# **AQUIND INTERCONNECTOR**

## **Environmental Statement Addendum – Appendix 1 Environmental Statement Errata Sheet**

Document Ref: 7.8.1.1

**DATE: 6 OCTOBER 2020**

SCALE AT A1: 1:75	CHECKED: J Crouch	APPROVED: J Crouch
PROJECT No: EN020022	DESIGNED: A Lenia	DRAWN: A Lenia
		DATE: 15/09/2020
DRAWING No: EN020022-2.10-EL-Sheet1	REV: 02

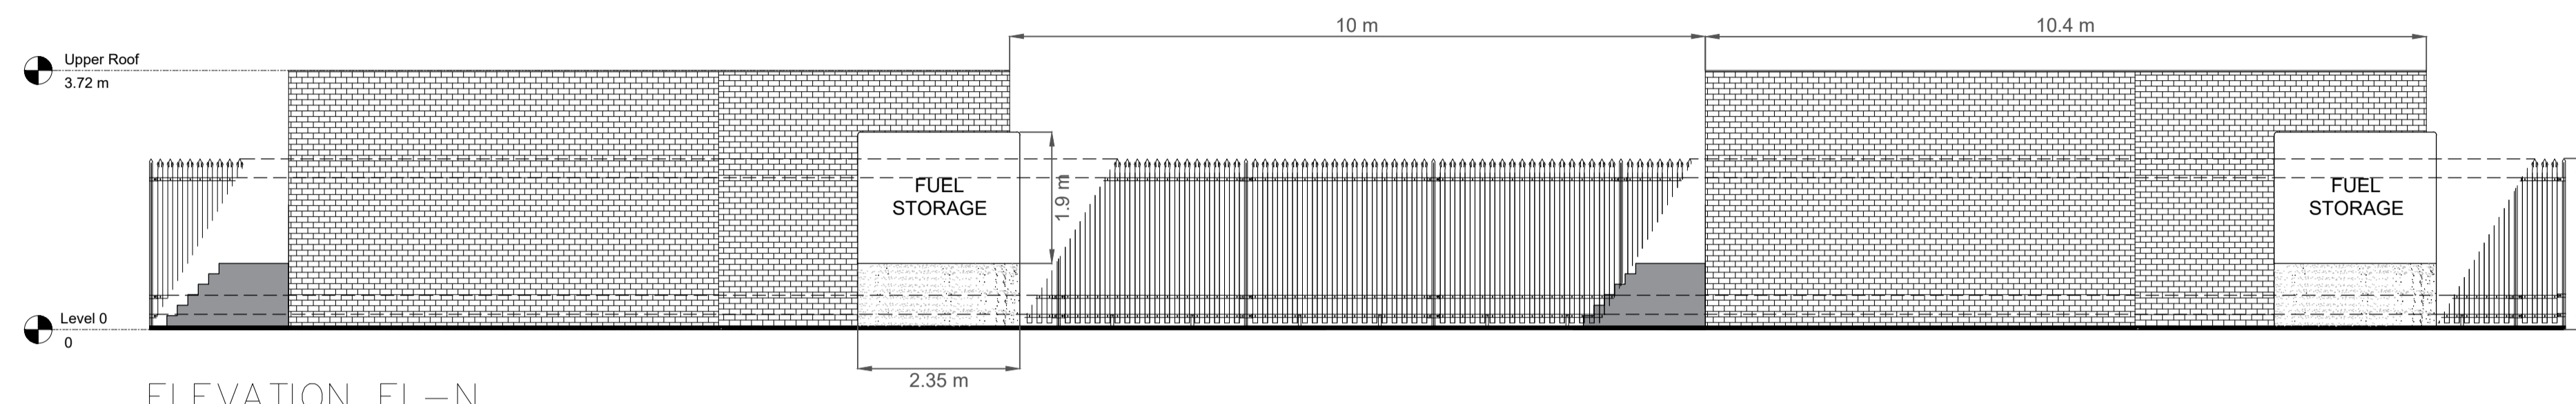
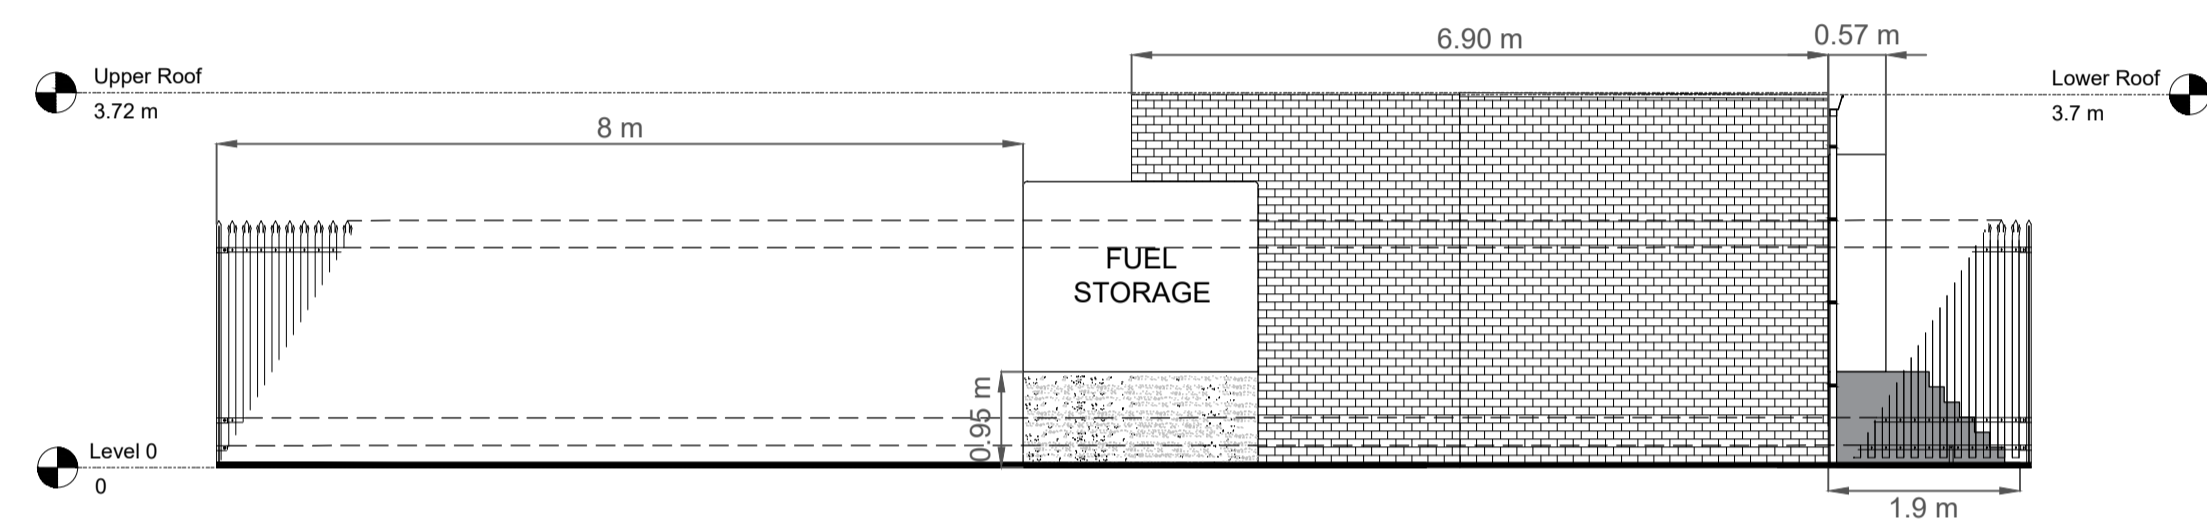
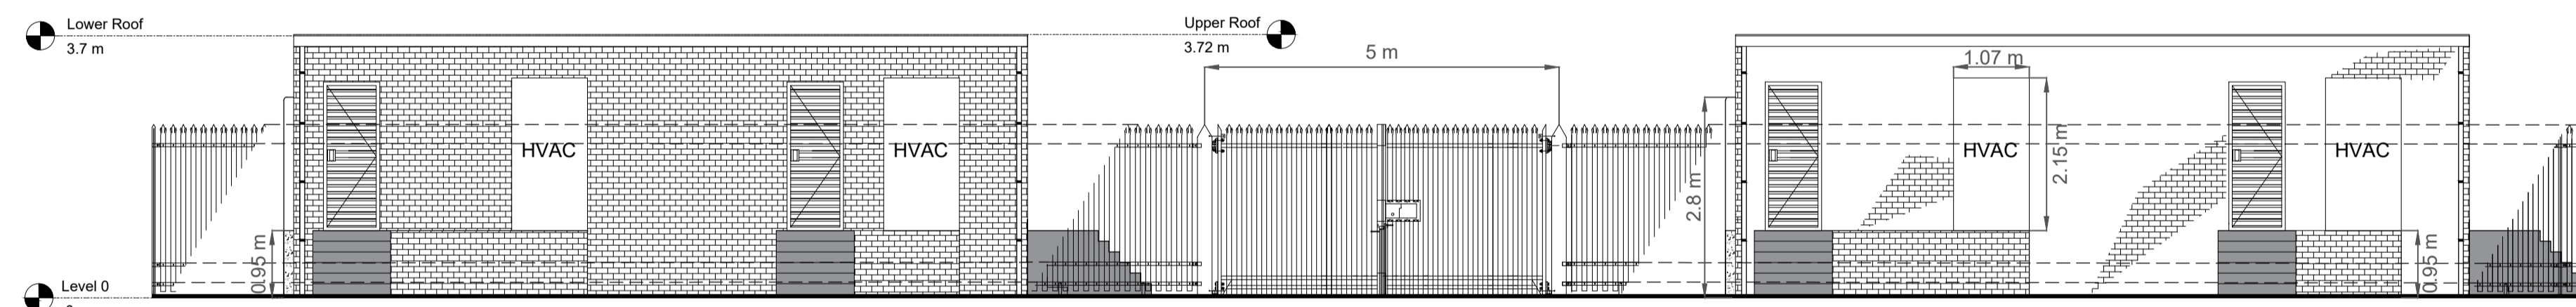
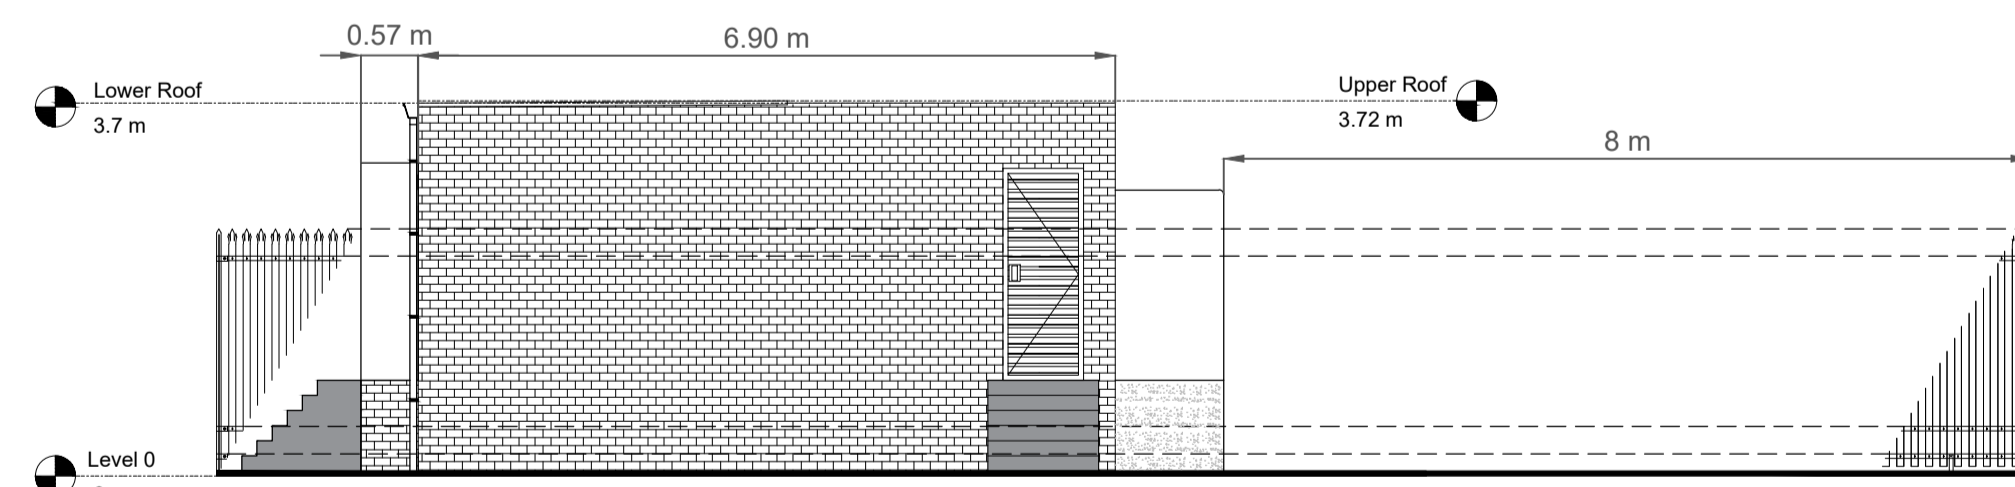
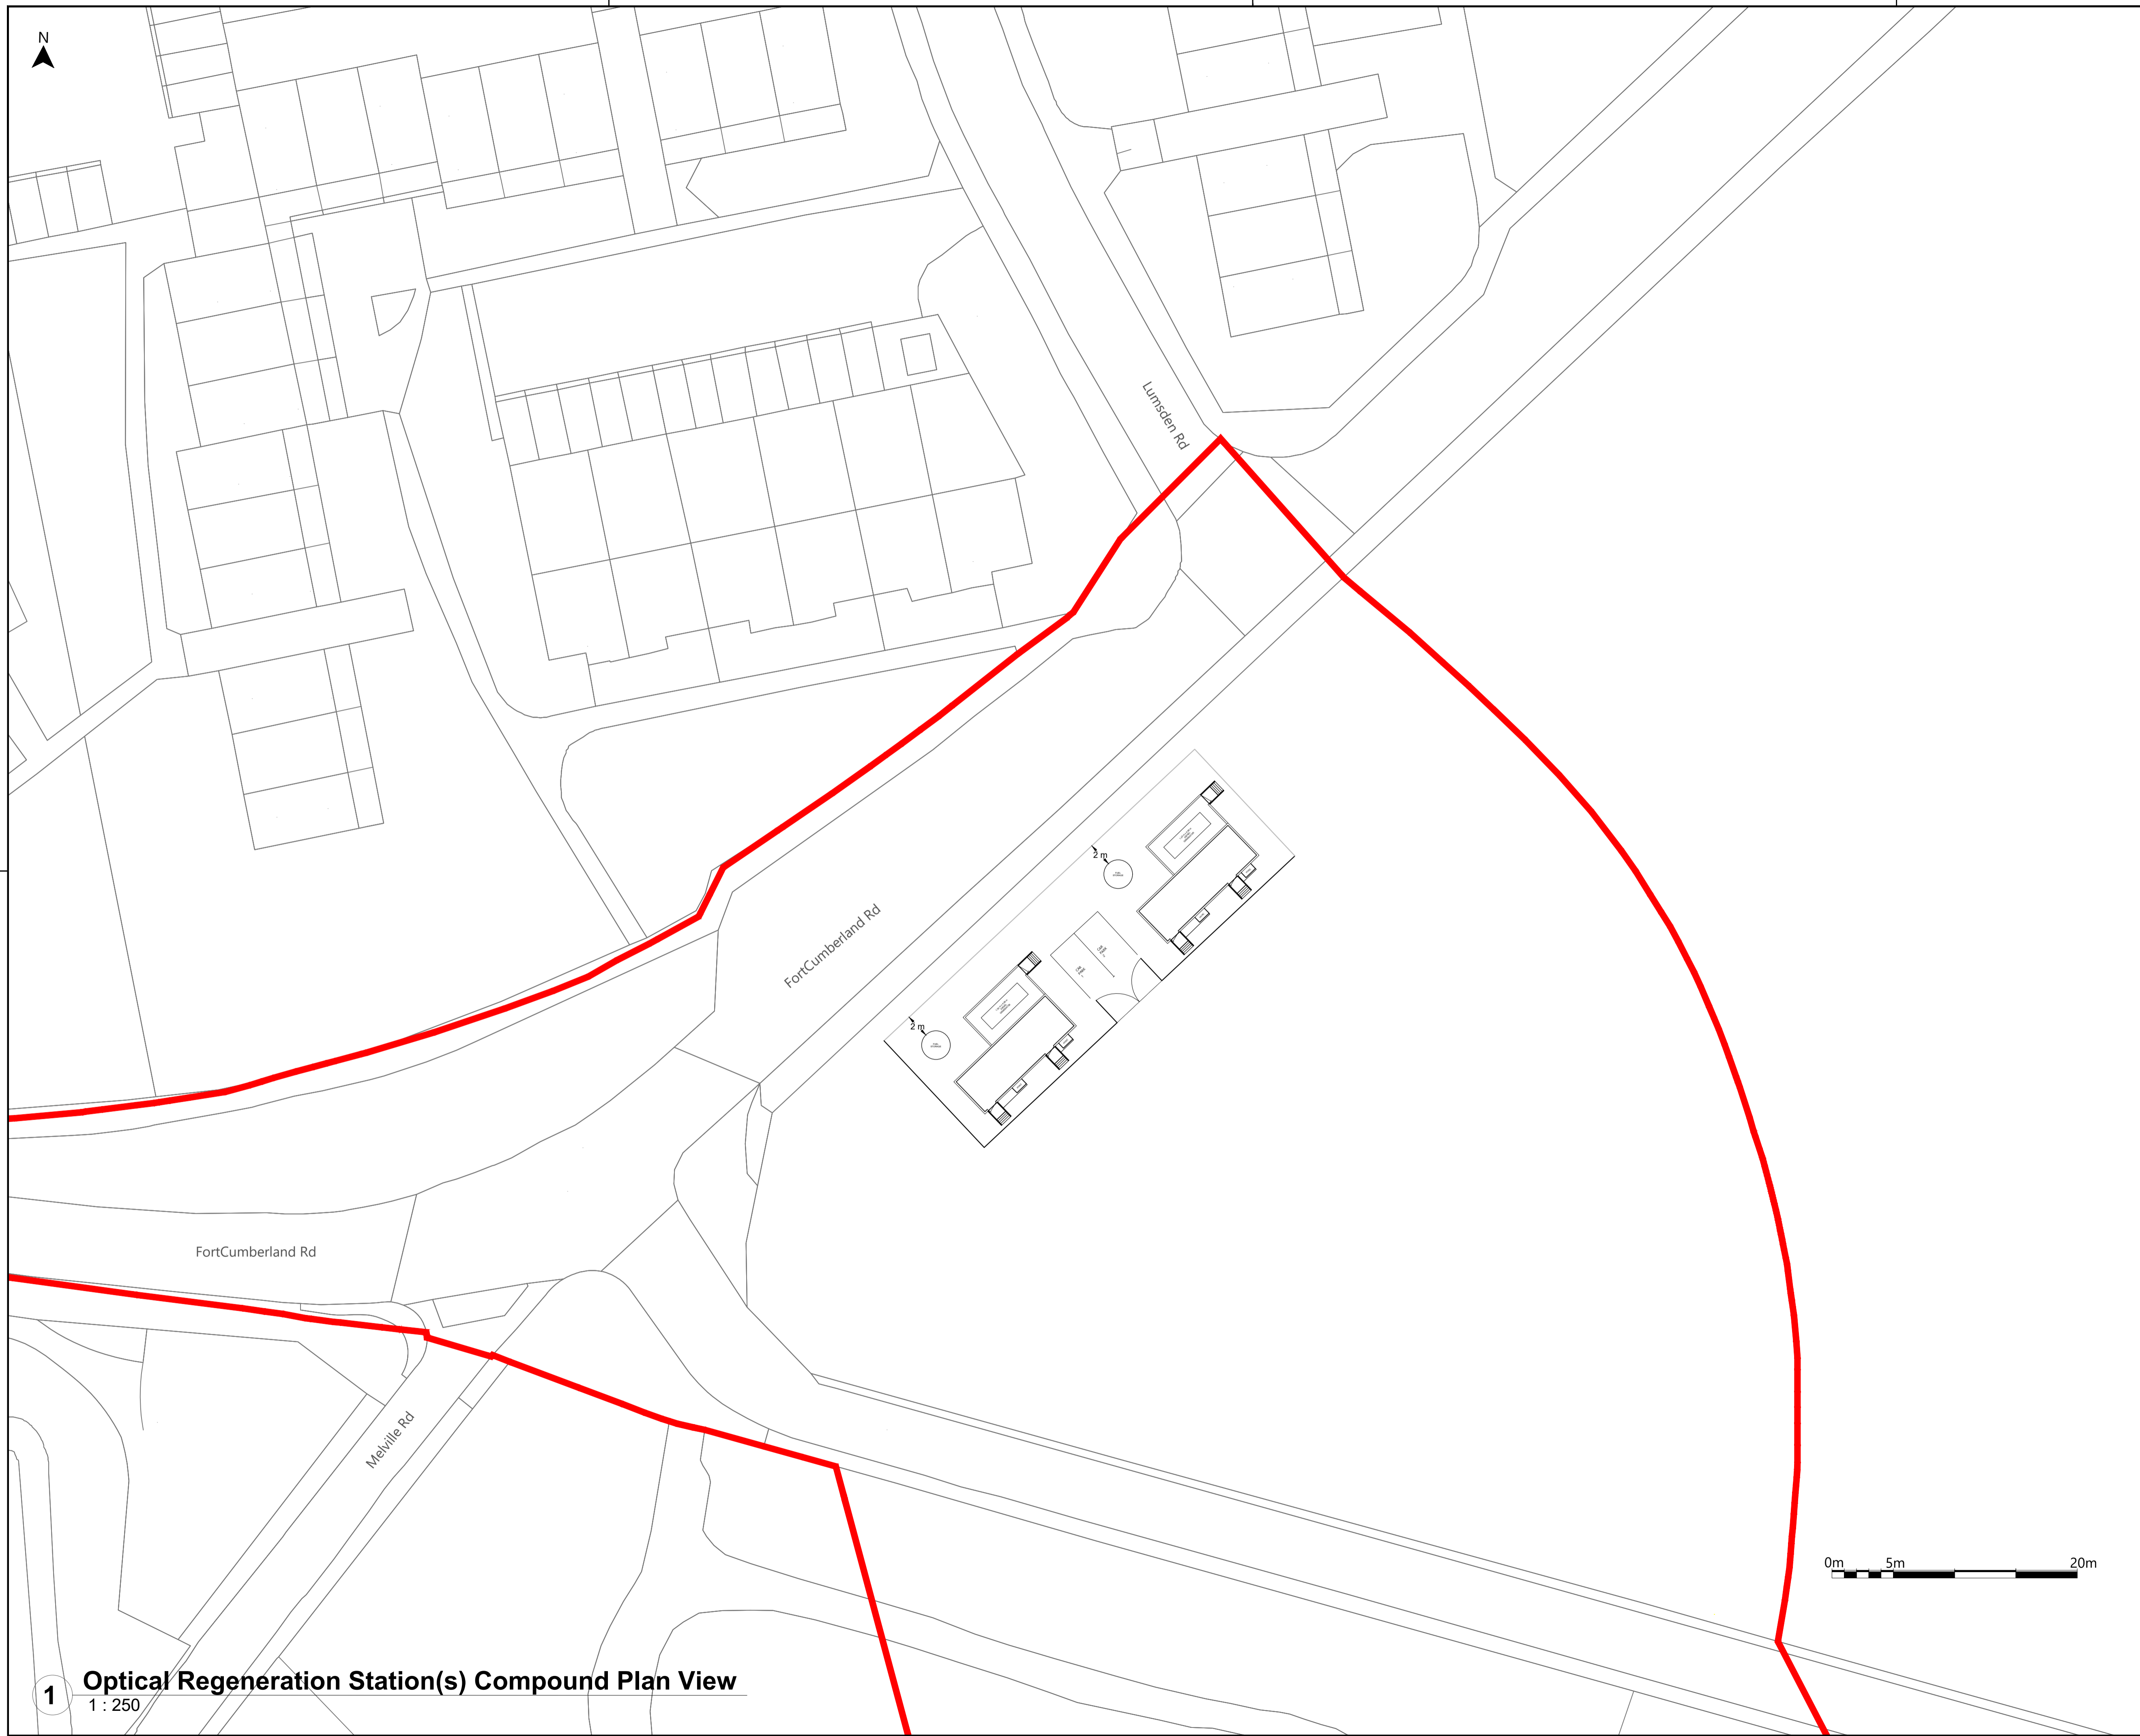
Location in the 2019 ES	Error noted in the 2019 ES	Amended text in ES Addendum
<b>Optical Regeneration Station(s) Parameter Plan (APP-017).</b>	bars and it is not clear what scale they should be printed or viewed at.	<ul style="list-style-type: none"> <li>• Indicative Telecommunications Buildings Elevations and Floor Plans (APP-015 Rev02);</li> <li>• Indicative Converter Station Area Layout Plans (APP-013 Rev02);</li> <li>• Indicative Optical Regeneration Station(s) Elevations and Floor Plans (APP-016 Rev02);</li> <li>• Optical Regeneration Station(s) Parameter Plan (APP-017 Rev02).</li> </ul> <p>Information relating to scale of the drawing and paper size is included within the drawing title block.</p>
<b>Funding Statement (APP-023)</b>	Paragraph 7.2.1 – incorrect reference to paragraph 7.4.3 instead of 7.2.3	Reference updated to refer to paragraph 7.2.3 instead.
<b>Marine Outline CEMP (APP-488)</b>	Paragraph 5.6.2.2 is incomplete	<p>Text has been updated to be read as follows:</p> <p><i>“Contractors will ensure that Cable Laying Vessels (‘CLV’) will display appropriate marks and lights, and broadcast their status on AIS at all times, to indicate the nature of the work in progress, and highlight their restricted manoeuvrability.”</i></p>

Location in the 2019 ES	Error noted in the 2019 ES	Amended text in ES Addendum
		<p>measures listed at Table 28.15 which are embedded within the Construction Stage’.</p> <p>For 28.6 in the ‘ES Source (Para)’ column it should state ‘<i>Table 28.19</i>’ and not ‘Table 28.17’.</p> <p>In the ‘Subject/ Potential Impact’ column it should state ‘<i>Embedded mitigation within the of the Converter Station design</i>’ and not ‘within the of the Converter Station design Embedded mitigation’.</p> <p>In the ‘Mitigation Measures (as set out in the ES)’ column it should state ‘<i>The mitigation measures listed at Table 28.19 which are embedded within the design of the Converter Station</i>’ and not ‘The mitigation measures listed at Table 28.15 which are embedded within the design of the Converter Station’</p>
<p><b>Indicative Telecommunications Buildings Elevations and Floor Plans (APP-015);</b></p> <p><b>Indicative Converter Station Area Layout Plans (APP-013);</b></p> <p><b>Indicative Optical Regeneration Station(s) Elevations and Floor Plans (APP-016);</b></p>	<p>The Indicative Telecommunications Buildings Elevations and Floor Plans, Indicative Converter Station Area Layout Plans, Indicative Optical Regeneration Station(s) Elevations and Floor Plans and Optical Regeneration Station(s) Parameter Plan appear to lack scale</p>	<p>The following plans have had scale bars added and have been resubmitted with this document:</p>
